October 8, 2014

STATE PROJECT: 34915.1.1 (U-3308)
F. A. PROJECT: STP-0055(20)
COUNTY: DURHAM
DESCRIPTION: NC 55 (Alston Ave.) from NC 147 (Buck Dean Freeway) to US 70 Business/NC 98 (Holloway St.)

SUBJECT: Temporary Shoring Recommendations for Location No. 4

4 TEMPORARY SHORING No.4
 QUANTITY = 624 SQ. FT.
 FROM -LALT- STA. 36+30 +/-, 7.9' +/- RT
 TO -LALT- STA. 38+25 +/-, 6.6' +/- RT

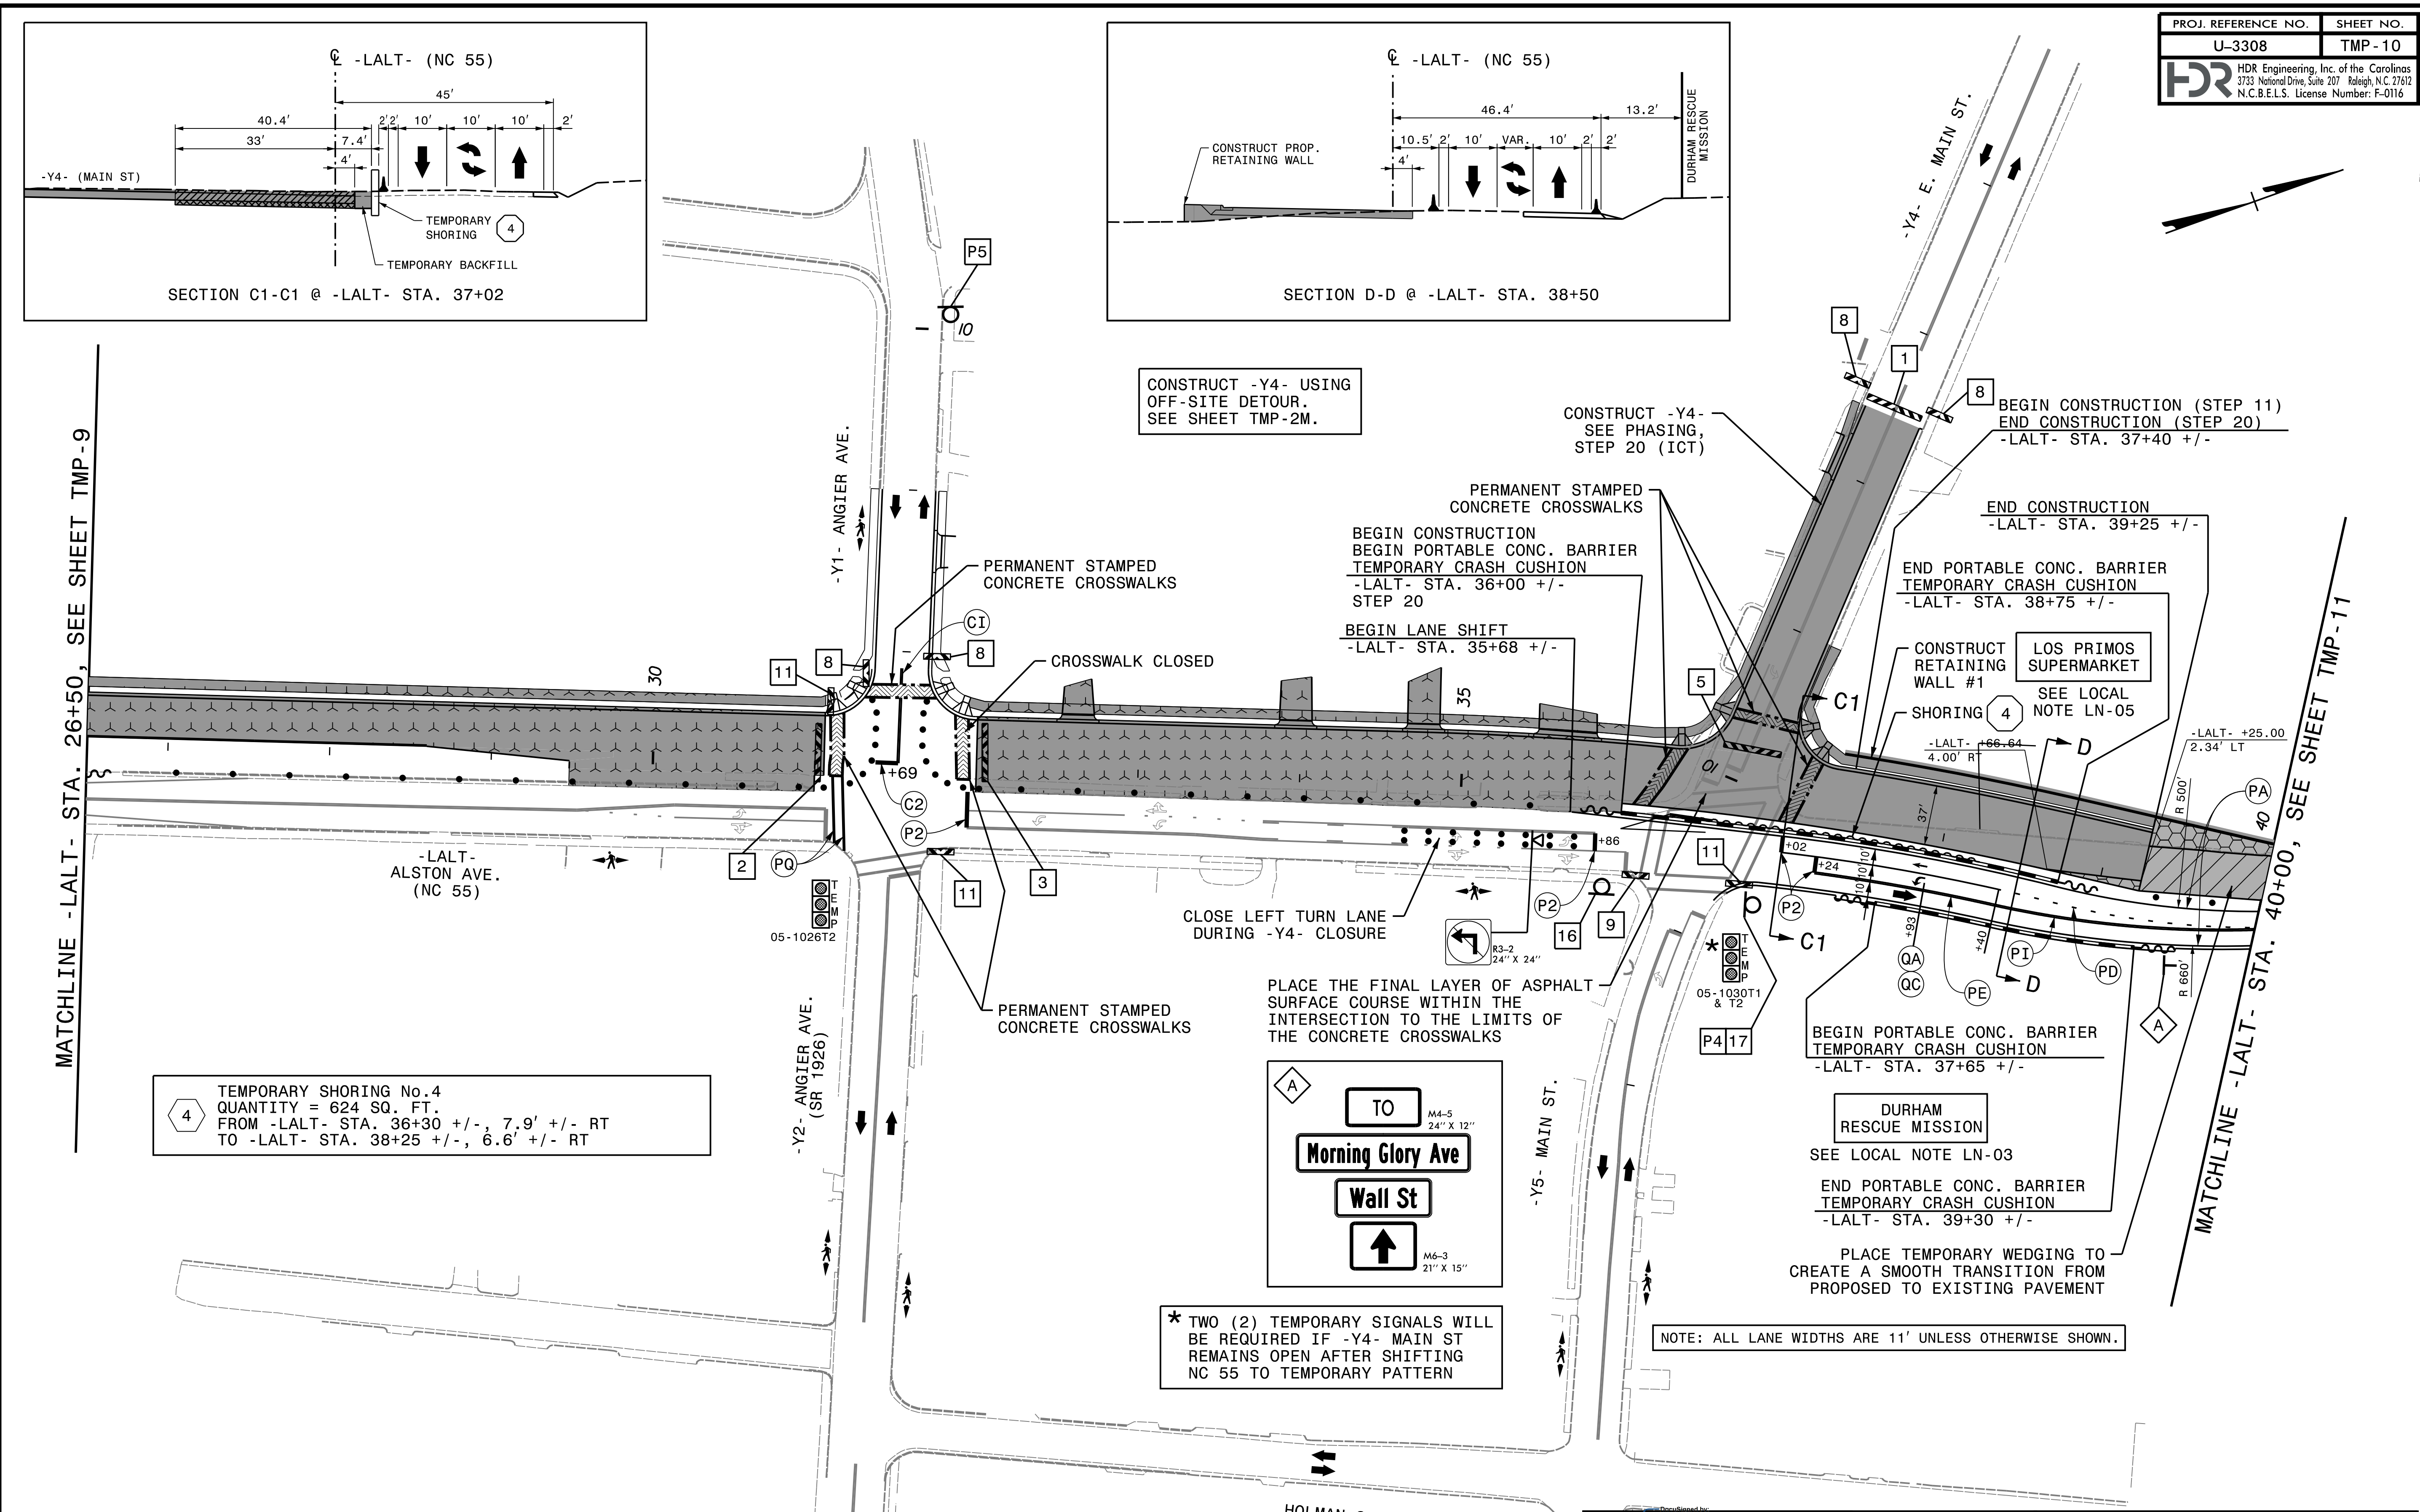
BEFORE BEGINNING TEMPORARY SHORING DESIGN OR CONSTRUCTION, SURVEY EXISTING GROUND ELEVATIONS IN THE VICINITY OF SHORING LOCATIONS TO DETERMINE ACTUAL SHORING HEIGHTS.

DESIGN TEMPORARY SHORING FROM STATION -LALT- 36+30±, 7.9 FT RIGHT, TO STATION -LALT- 38+25±, 6.6 FT RIGHT, FOR THE FOLLOWING ASSUMED SOIL PARAMETERS AND GROUNDWATER ELEVATION:

UNIT WEIGHT (γ) = 120 LB/CF
FRICTION ANGLE (ϕ) = 24 DEGREES (RESIDUAL SOIL)
FRICTION ANGLE (ϕ) = 30 DEGREES (EMBANKMENT SOIL)
FRICTION ANGLE (ϕ) = 36 DEGREES (WEATHERED ROCK)
COHESION (c) = 0 LB/SF
GROUNDWATER ELEVATION = 349.0 FT. ±

DRIVEN PILING FOR TEMPORARY SHORING FROM STATION -LALT- 36+30±, 7.9 FT RIGHT, TO STATION -LALT- 38+25±, 6.6 FT RIGHT, MAY NOT PENETRATE BELOW ELEVATION 356 FT DUE TO OBSTRUCTIONS, VERY DENSE OR HARD SOIL, BOULDERS OR WEATHERED OR HARD ROCK.

DO NOT USE A TEMPORARY WALL FOR TEMPORARY SHORING FROM STATION -LALT- 36+30±, 7.9 FT RIGHT, TO STATION -LALT- 38+25±, 6.6 FT RIGHT.
